DEVELOPMENT HEARING OFFICER - HYDROLOGY SECTION
Anthony Montoya, Jr., PE, Senior Engineer | 505-924-3314 amontoya@cabq.gov

DRB Project Number: 2020-003484 Hearing Date: 01-22-2025
Project: Volcano Cliffs, Lots 2 & 3, Blk 12, Unit 3 Agenda Item No: 3

DRB Project No: PR-2020-003484 Date: 1/22/2025 Agenda Item: #1 Zone Atlas Page: E-10

Application For: SD-2024-00158 – EXTENSION OF PRELIMINARY PLAT (DHO)

PRELIMINARY PLAT FOR
MOJAVE RIDGE SUBDIVISION
(A REPLAT OF LOTS 2 & 3, BLOCK 12,
UNIT 3, VOLCANO CLIFFS SUBDIVISION)
WITHIN
SECTION 27,
TOWNSHIP 11 NORTH, RANGE 2 EAST, N.M.P.M.
CITY OF ALBUQUERQUE
BERNALILLO COUNTY, NEW MEXICO
JANUARY, 2023

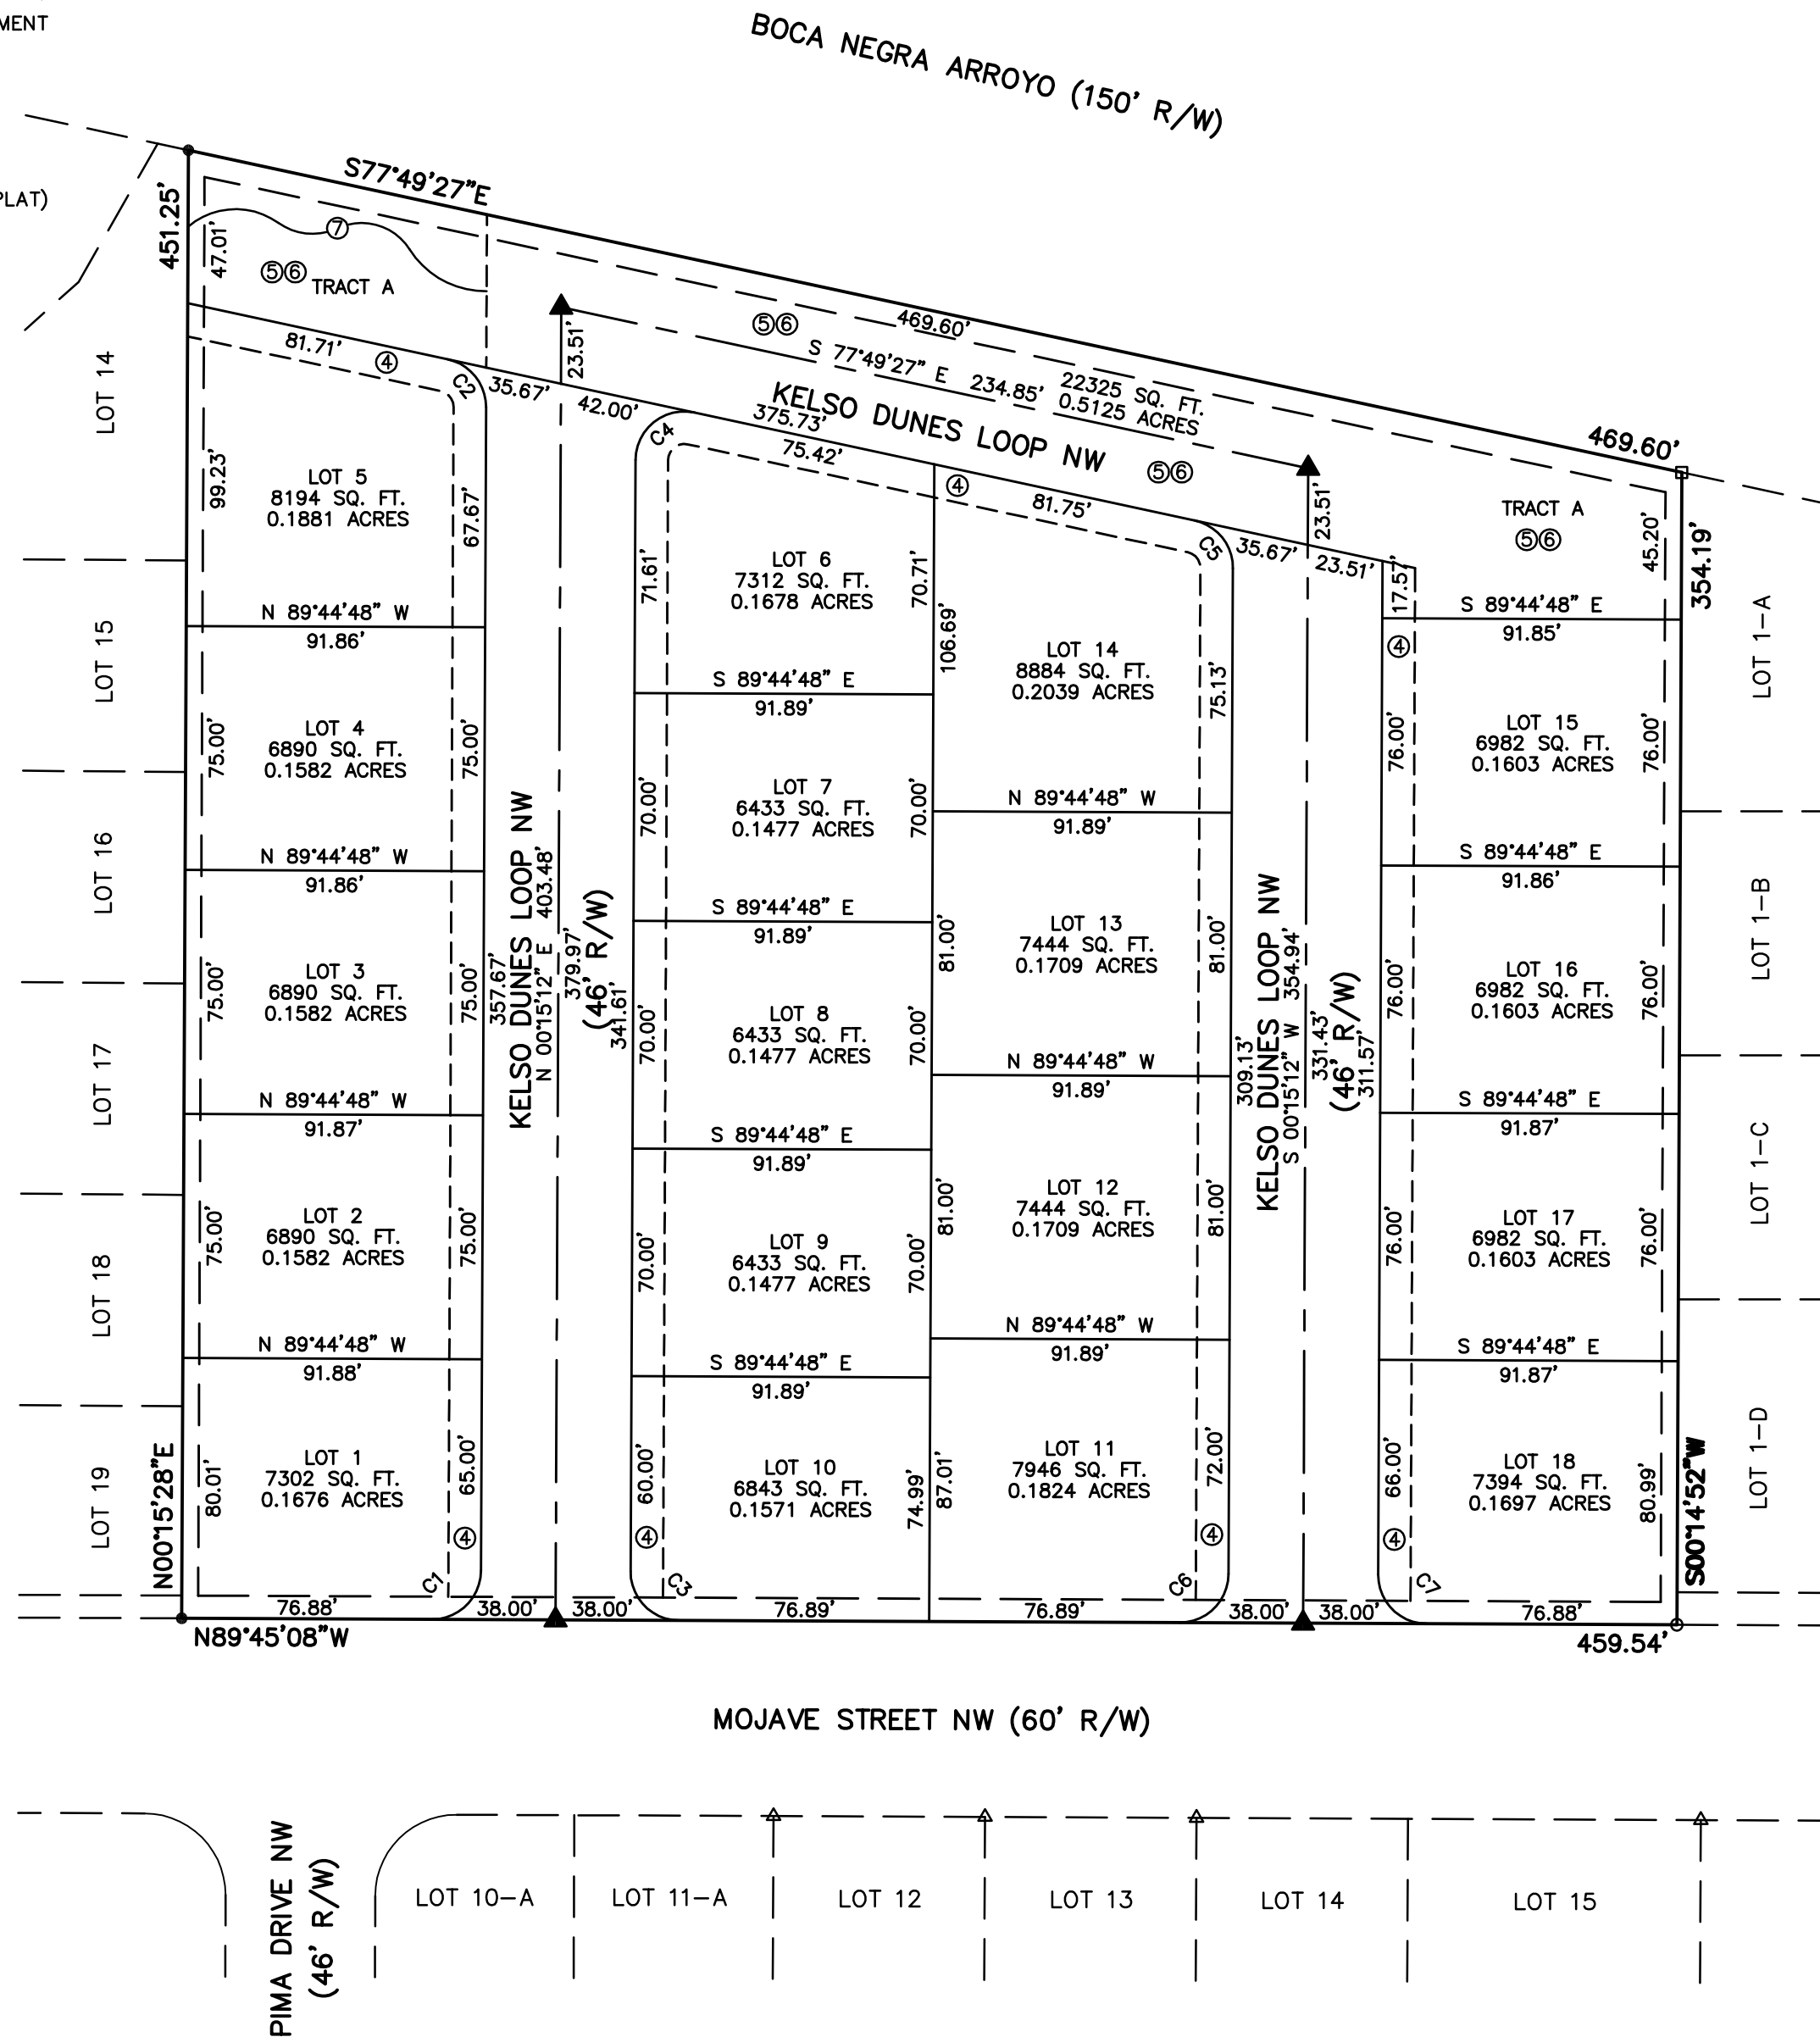
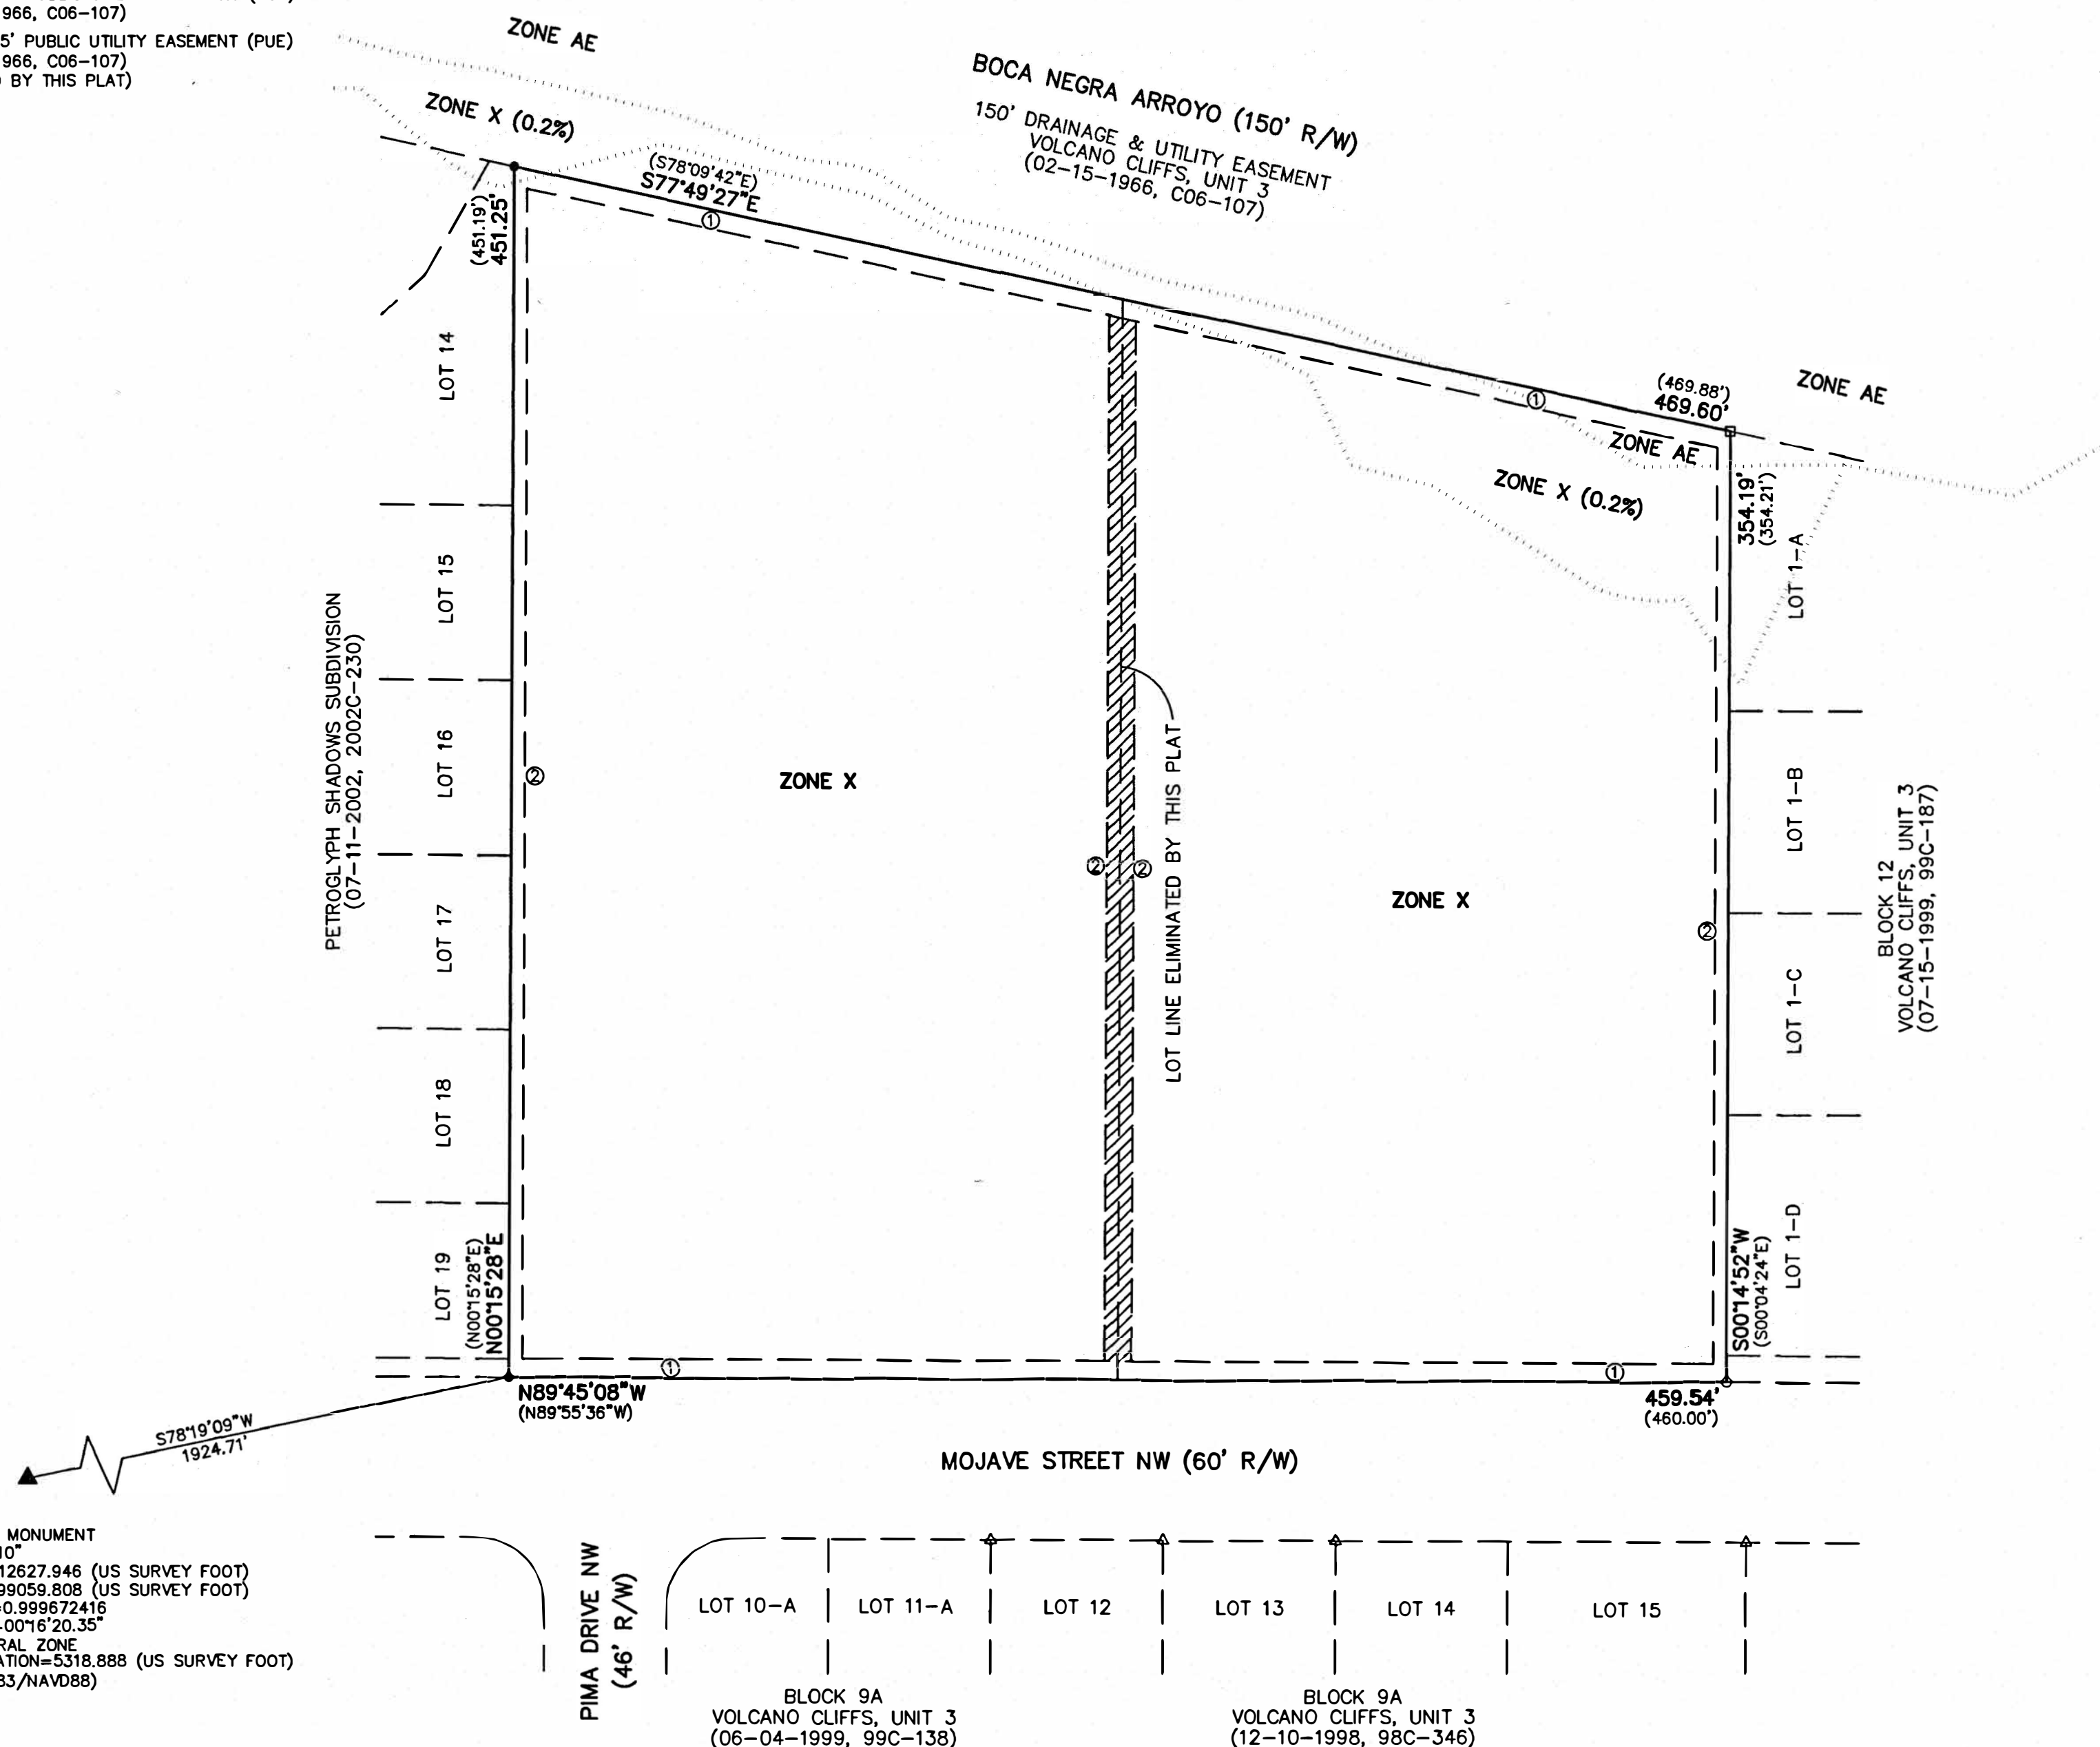
4. Financial Guarantee:
A financial guarantee or construction completion of all required infrastructure is required prior to final plat signature.
5. DHO Application form under “Brief Description of Request” indicates that there are a total of 19 lots, however the Preliminary Plat is showing only 18.
